Application No: EP/124/20/HH
Site Address: Little Dormers 23 Upper Drive East Preston BN16 1QN
Description of works: New bay and porch skirt roof to the front elevation, and roof linked detached double garage.

Thank you for your internet representation made on 27th November 2020 which has been recorded as an objection with the comments as follows:

The Angmering on Sea Residents Association (AOSERA) OBJECTS to the proposed development of 23 Upper Drive, BN16 1QN on the following grounds:

Drawing Name
Elevations-
Proposed

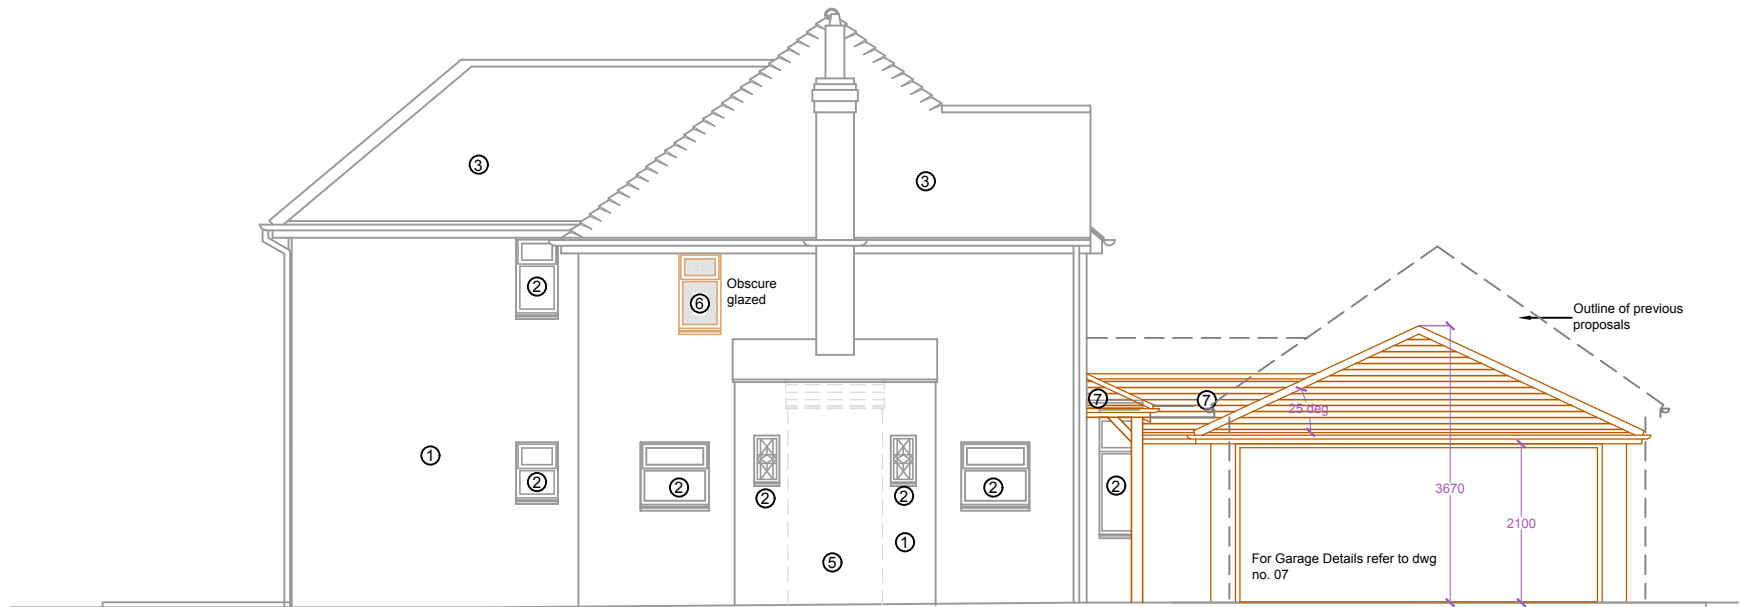
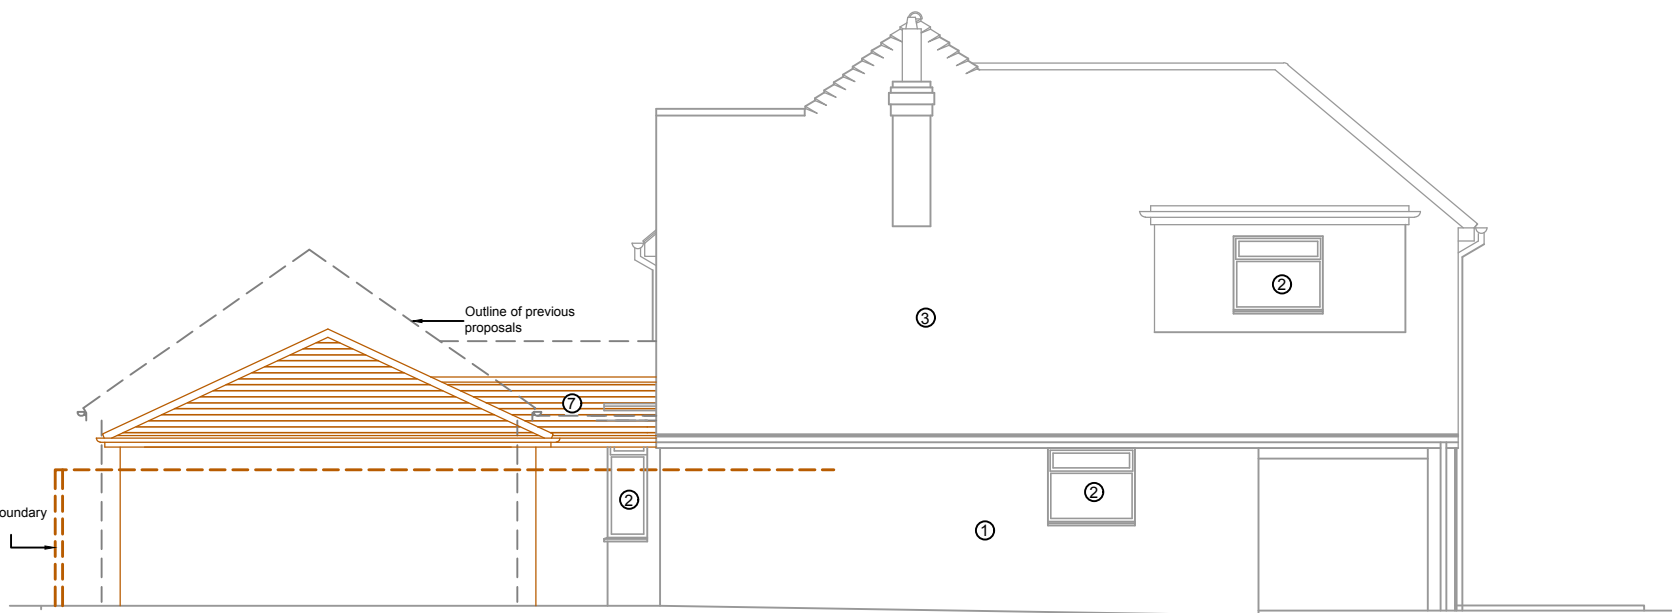
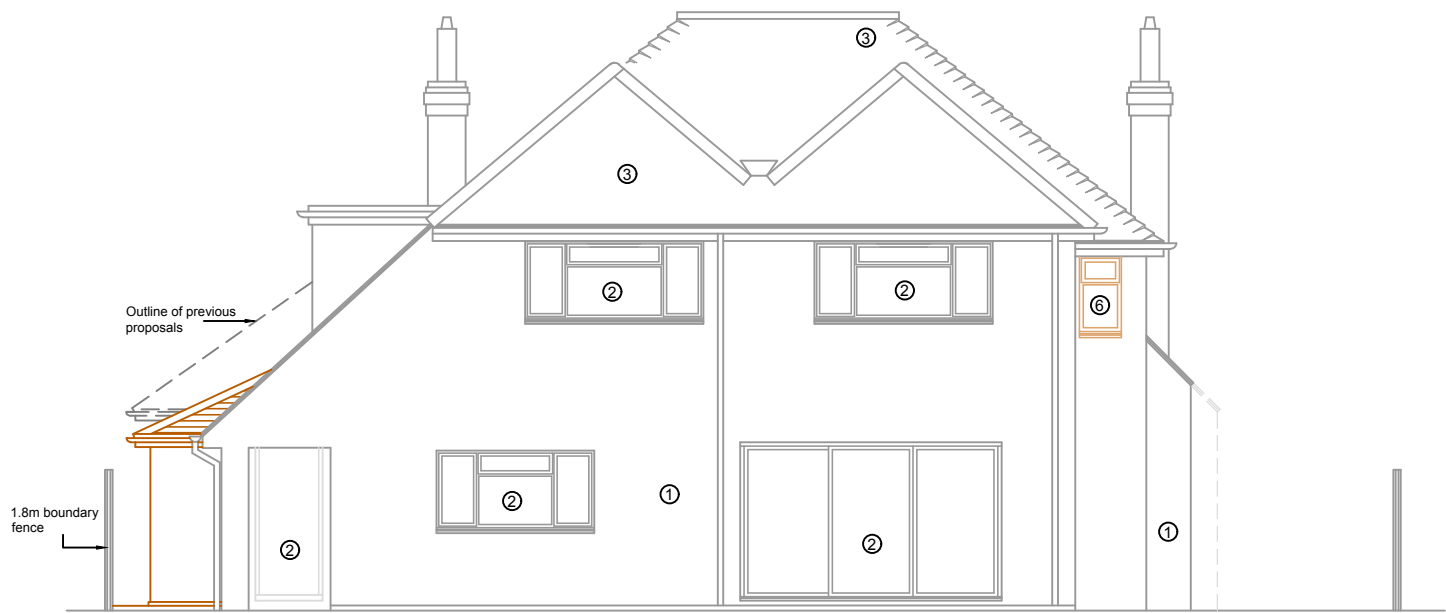
The proposed extension is out of character with the host building and all neighbouring properties in that section of Upper Drive. Its scale, and siting have a negative impact on its neighbour at 25 Upper Drive. The proposed building is large, tall and close to the boundary with No. 25 and will block the light into the front of No 25. The proposed extension will not be subservient to the host building.

Garage Plans and Elevations -
Proposed

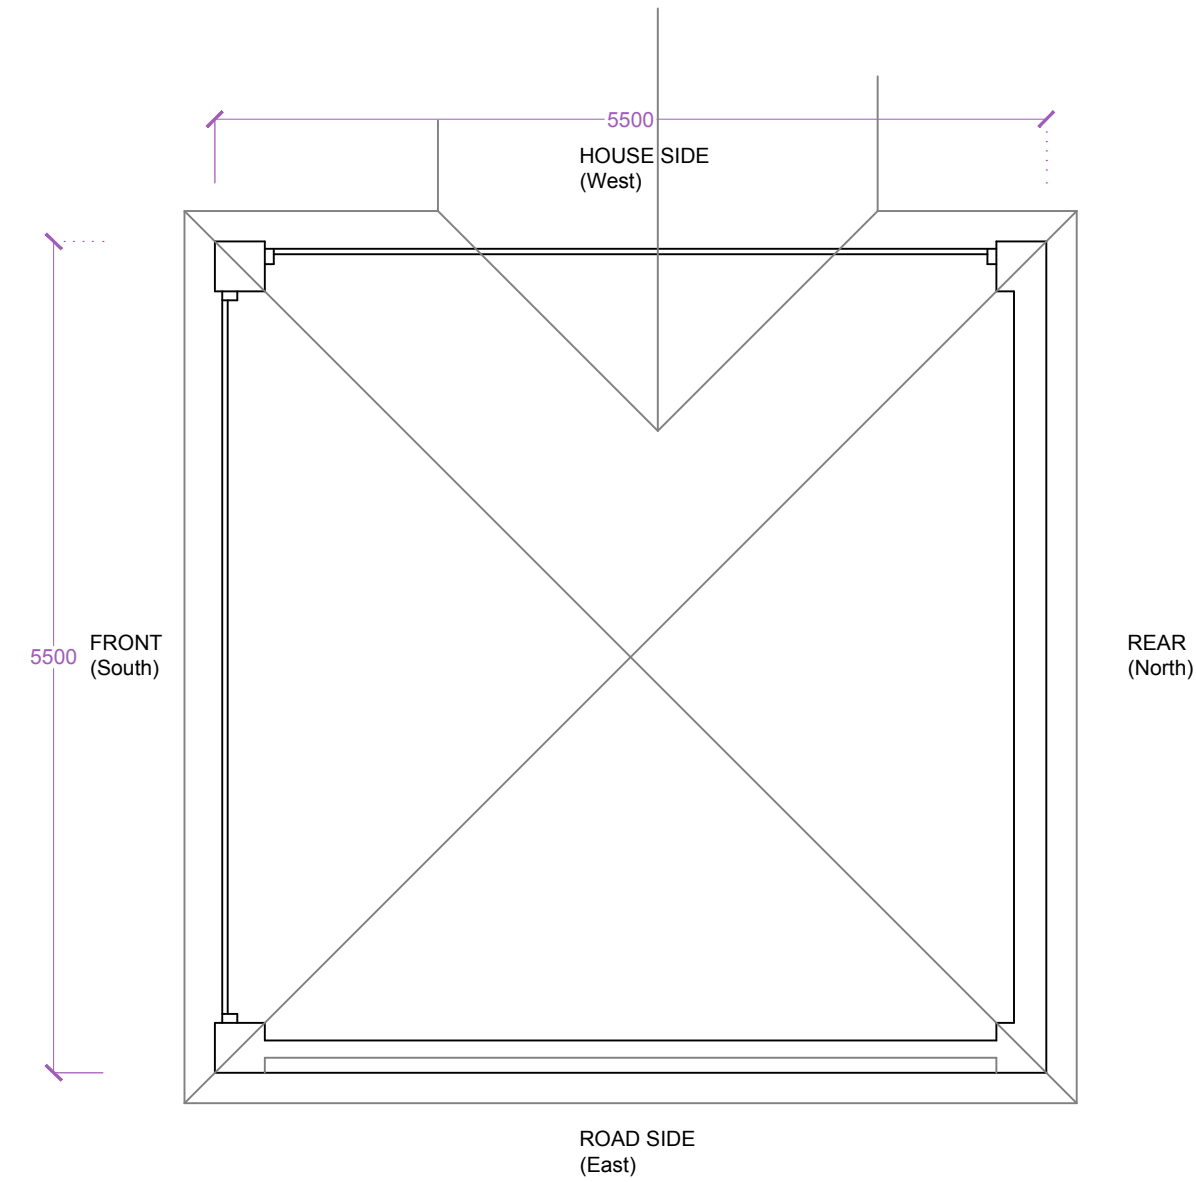
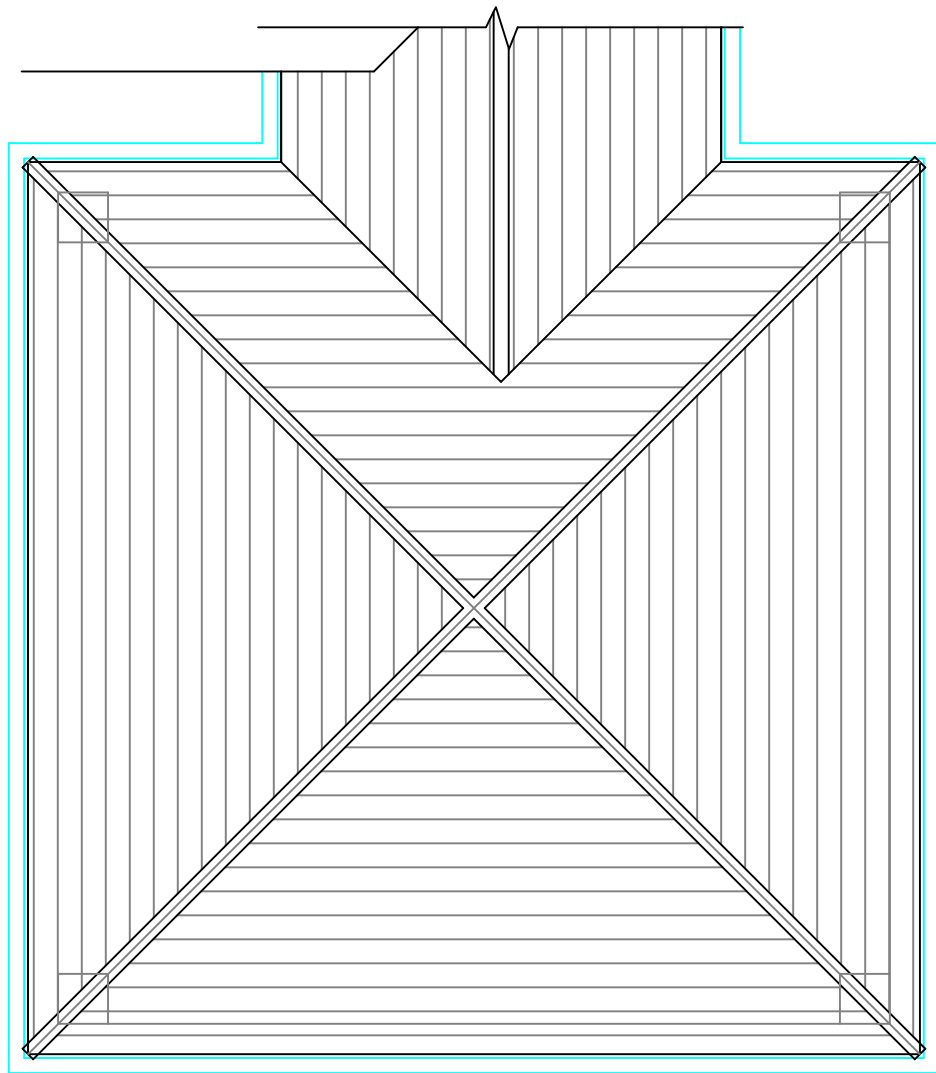
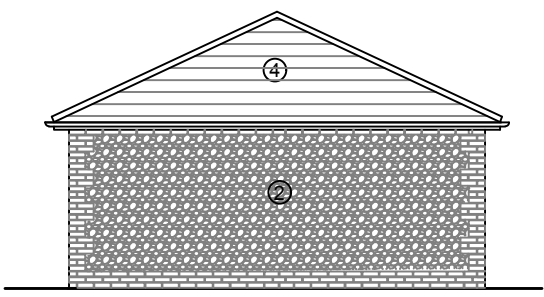
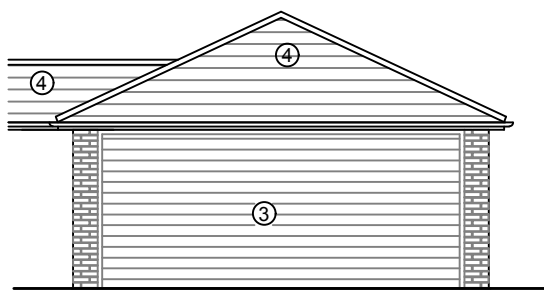
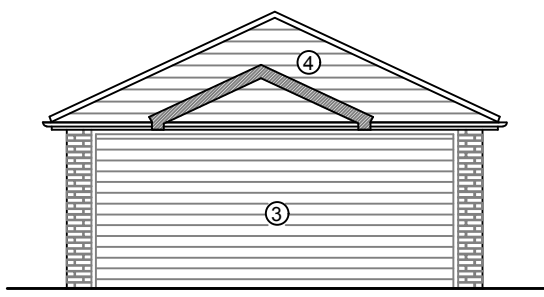
The garage will also have a negative impact upon the street scene as the scale of the development will not be sympathetic to the overall character of the street. An extension as highly visible as is proposed will have a negative impact upon the existing street scene and should respect the established spatial character and pattern of the street.

The proposed extension will overlook and overshadow the neighbouring house No 25. The proposal does not

demonstrate, through its scale and siting, a recognition of its likely impact upon its neighbour and the proposal is not subservient to the host property.

Policy 1 of the EPNP in that its overall size and height (D=5.5m x W=5.5m x H=3.67) is too large for the front of the property and will create a general feel of being overbearing and overshadowing. The EPNP states that 'The enlarged house should not be unbalanced in appearance or so large as to be out of scale with other houses in the road. It should harmonise with other houses in the road in scale, design and materials (...) They should not be visually intrusive or alter the pattern of the street scene.' (para 4.16). In this case, the proposal, if approved, will be out of scale with other houses in the road, and will not be harmonised with other houses as no such other development exists.
